DELEGATED HOUSEHOLDER DECISION

1.2 Proposed Scheme

The application seeks householder planning permission for the erection of a single storey rear extension, conversion of garage to habitable space, erection of raised decking to rear, conversion of roof space to habitable use to include a rear dormer with Juliette balcony and 3no. roof lights, and amendments to fenestration.

61 ST LAWRENCE DRIVE EASTCOTE PINNER

## Drawing Title Loft Plans

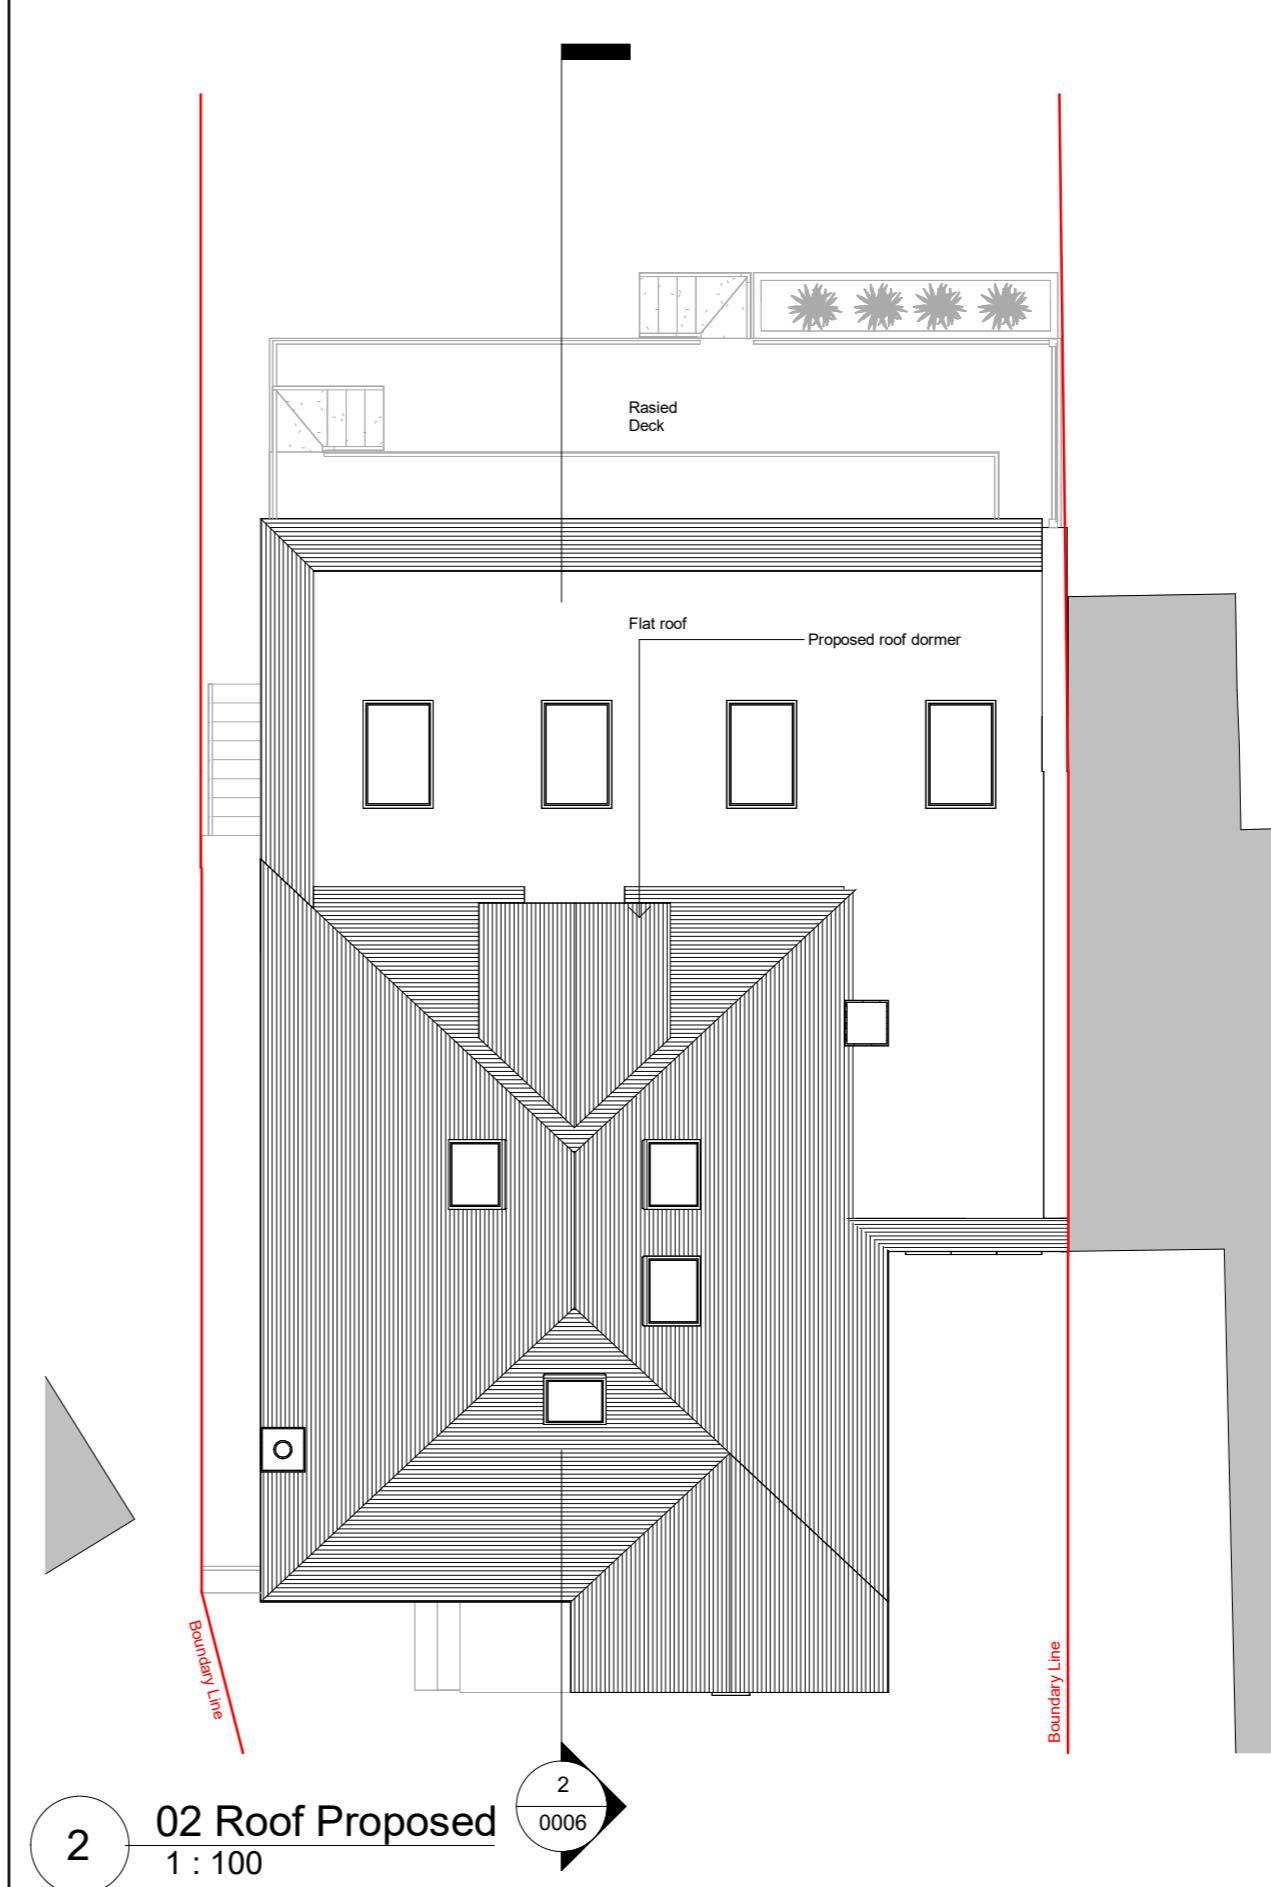
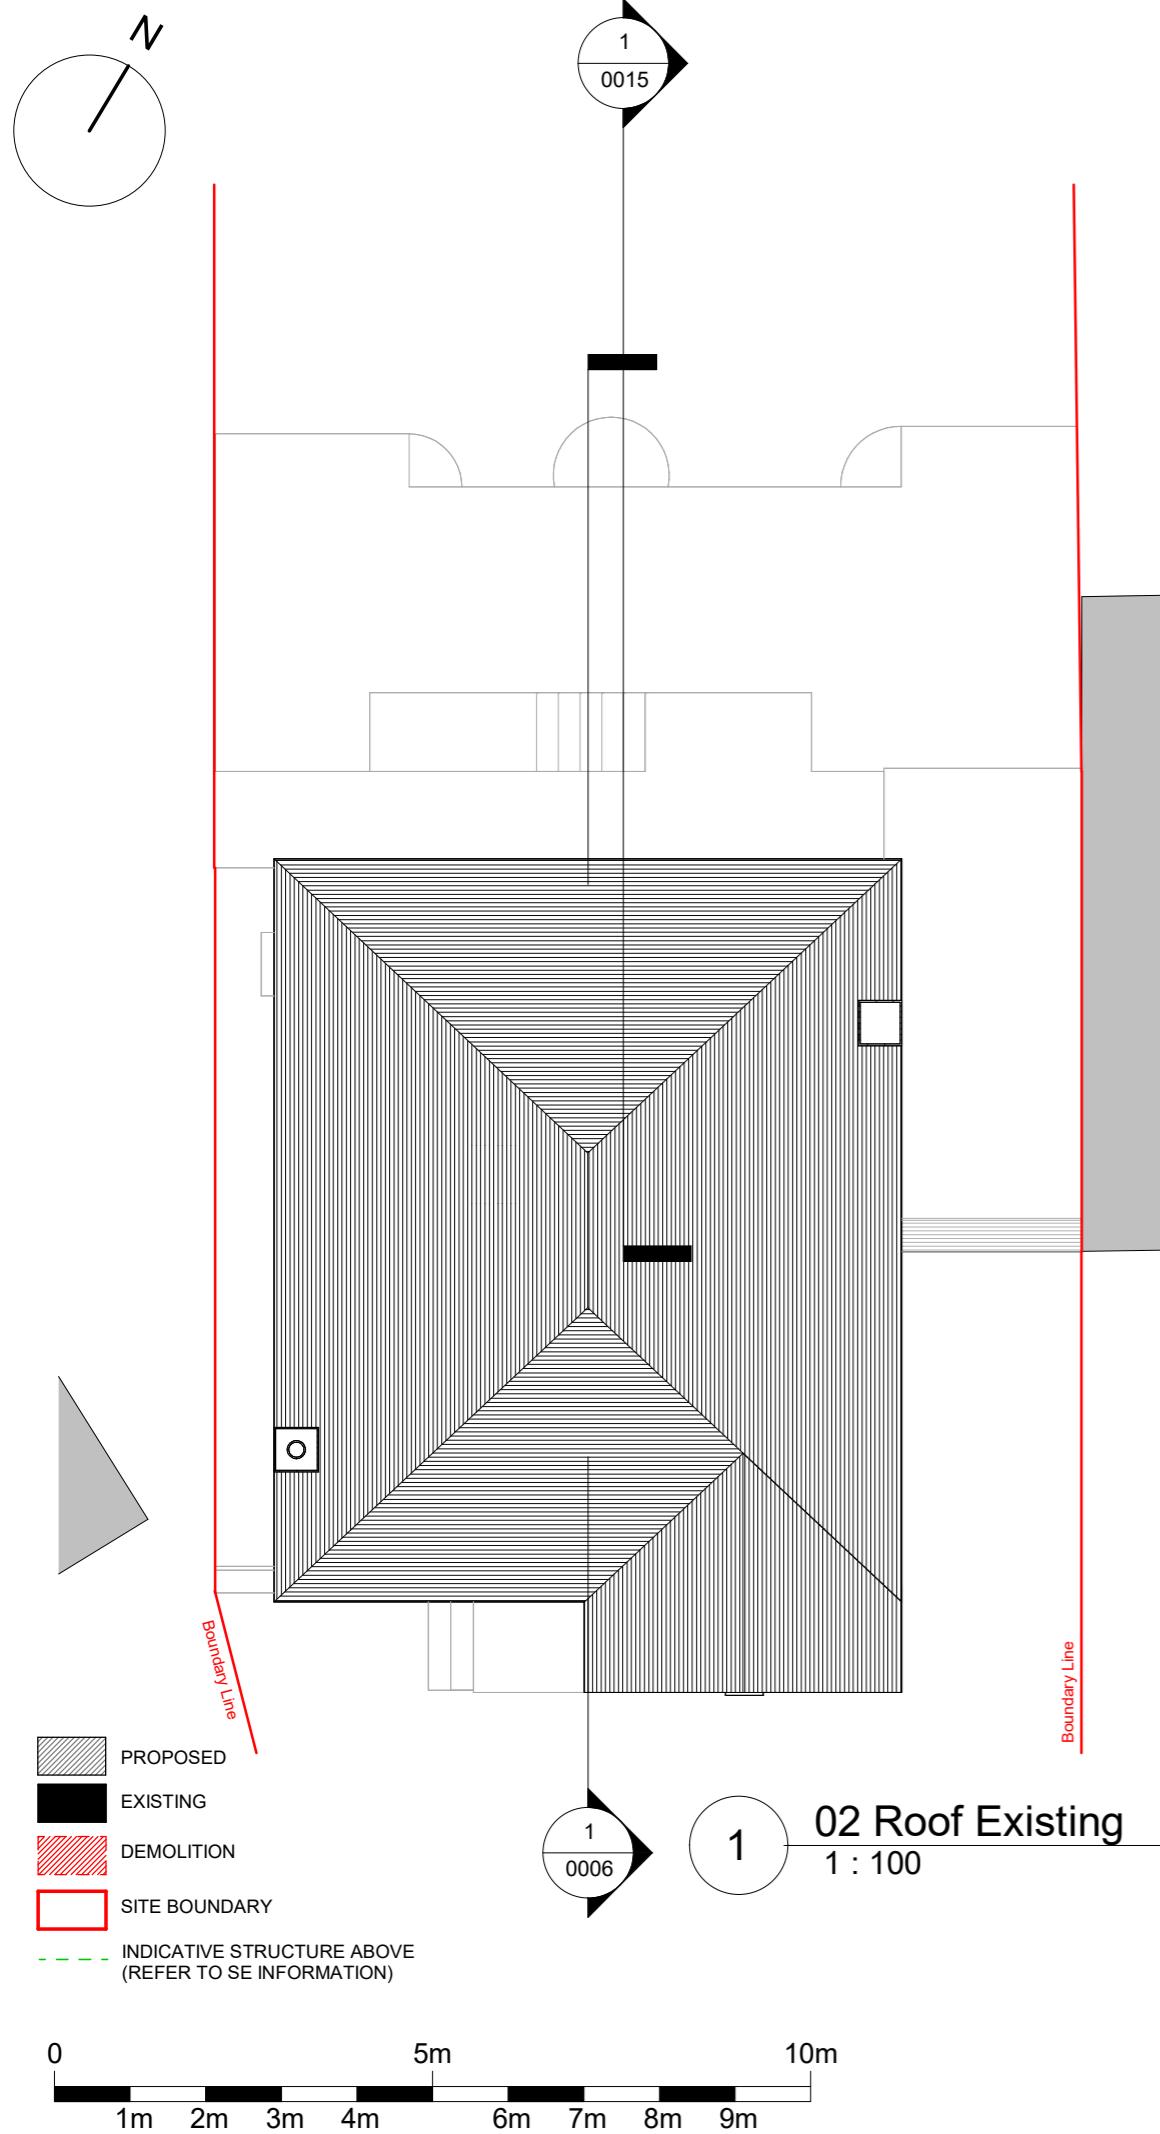
Conservation and Urban Design Officer - It is recommended the chimney be retained and the roof lights removed as they are not necessary given the internal layout. Particularly, as the side roof elevation is visually prominent. No objection to the rear extension and incorporation of the garage to habitable space and alterations to the front elevation.

Chimneys are a unique feature in the area which must be retained. Given this, amendments were sought whereby this feature was retained. Although, the Conservation officers had recommended that the roof lights be removed, upon visiting the site and the wider area, the Planning officer could see that there was a need for rooflights to allow adequate levels of sunlight to penetrate the habitable spaces and there was also evidence of rooflights in the area. (21, 26 and 36 St Lawrence drive. The roof light that could be seen from the street scene was however removed and the 3 rear ones are retained.

- The scheme has been assessed in line with policies as outlined below.
- Amended plans were sought in line with the conservation officer comments whereby the chimney was retained. This is all further assessed below.
- The current property has not been widely developed and therefore the current form of development is not considered overdevelopment,
- The rooflight on the side elevation was removed which would address the Conservation Officer concerns.

rawing Number  
40068-PI -D 0009

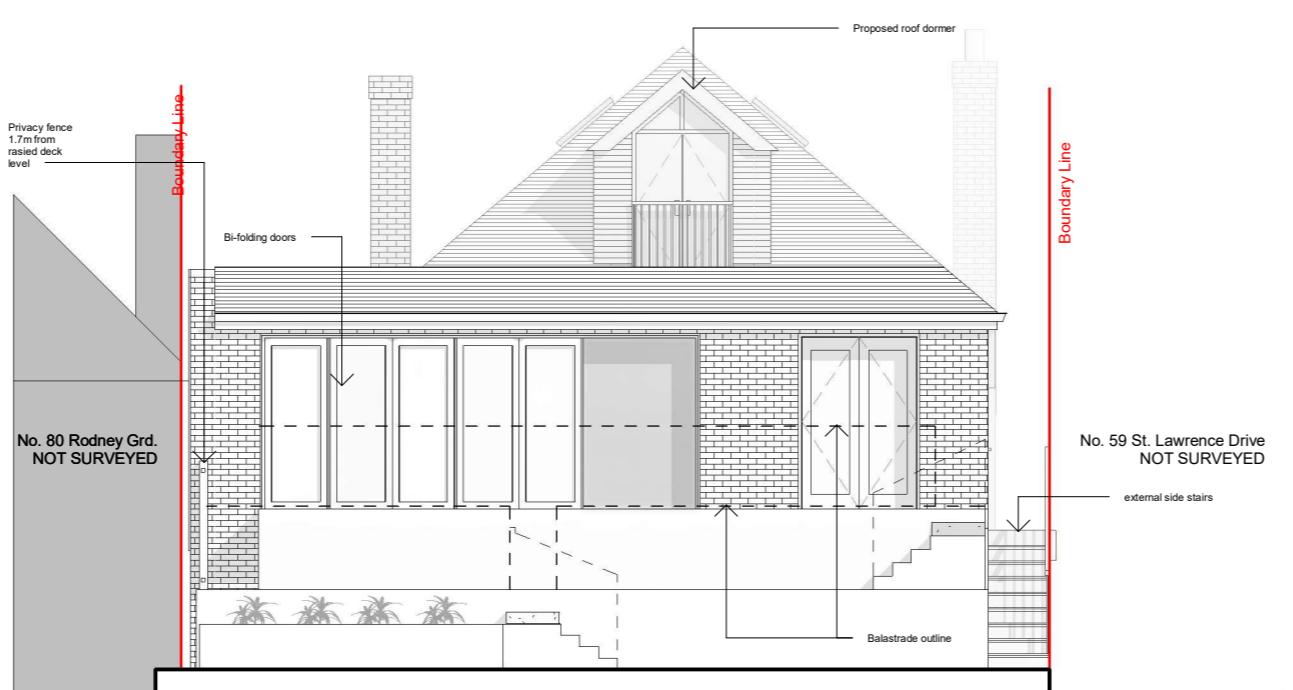
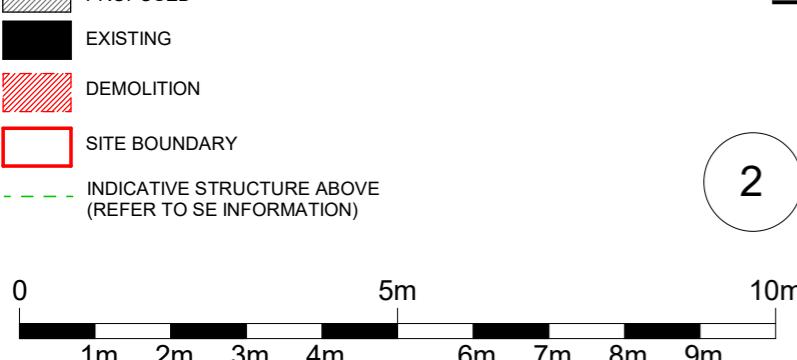
The scheme proposes a rear dormer with a Juliette balcony. The dormer on the rear would not go any higher than the highest section of the existing ridge and is in fact set down by 0.4m. Given this, and the fact that this feature is to the rear and would be seen from the front profile, this is acceptable and supported by officers. The rear dormer would be acceptable by reason that it sits comfortably on the roof profile. The dormer is 3m in depth, 2.6m in width and 2.8m in height and is acceptable as there are no side facing windows. The scheme proposes roof lights which are acceptable as well. The Juliette balcony proposed would have a similar outlook to a bedroom window and is therefore acceptable and raises no concerns. The proposed dormer would be appropriately set down from the roof's ridge line, up from the eaves, and in from the property's sides. The works would appear subordinate and subservient to the main dwelling and would not be an overly large roof extensions.

Given the nature of the properties in this area, a staggering patio is a common feature. The host dwelling as it currently sits has a patio feature on site. The rear patio along the boundary with No. 80 Rodney Garden will be increased in depth whereby it would be further out but the overall height would remain the same as existing. It is unlikely the increase in depth of the patio would adversely impact the neighbouring property especially as 1.7m screening will be provided. Furthermore, this

patio element would have a staggering nature whereby the 2m patio (above ground level) would go down to 1m and then 0m and given the limited depth of the patio before it reaches ground level, there is not enough depth at each level for it to be used to full capacity and given this, it is understood that the patio is merely a means to reach the garden. Given this, the patio is supported by officers.

A 1.8 metre high fence or imperforate wall shall be maintained on the boundary with 80 Rodney Gardens for the full depth of the patio hereby approved, and shall be permanently retained for so long as the development remains in existence.
